Recommendation Report for Planning Permission for Works or Extension to a Dwelling

REF NO: BE/51/20/HH

LOCATION: 33 Hazel Road
Bersted
PO22 9EA

PROPOSAL: Demolish existing lean-to side (w) elevation & rebuild single storey side/rear extension.

PROPOSED ELEVATIONS 1:100 @ A3

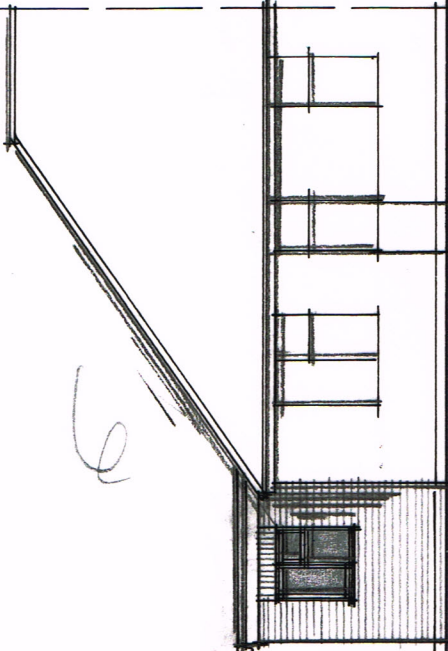
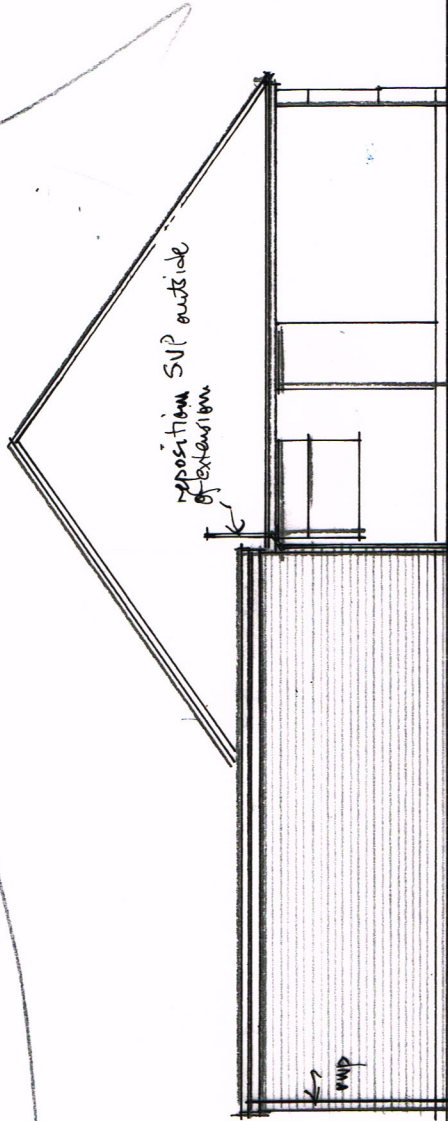
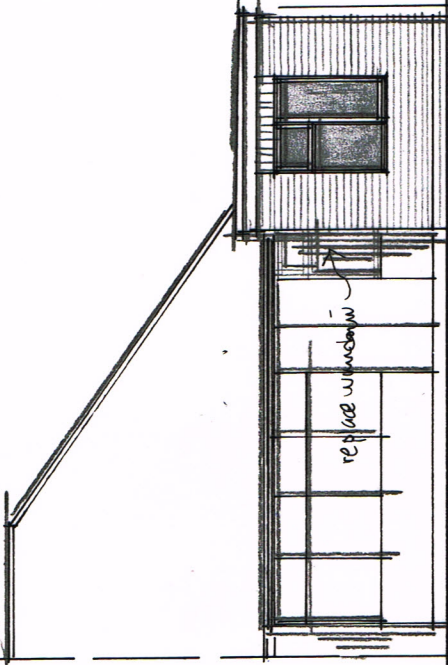
The extension will be set further back than the existing garage around 5.75m behind the principal elevation. It will then run along the side elevation and extend around 2m beyond the rear.

It will be constructed of brick which will match the existing dwelling. The proposal is modest in size and appears subservient to the host dwelling.

The side addition will have a width of 2m and run along the boundary extending beyond the rear elevation by 2m which is 1m additional than the existing structure. It will have a height of 2.75m.

There are no windows proposed to the side elevation, with additional windows to the east overlooking the garden of the host dwelling.
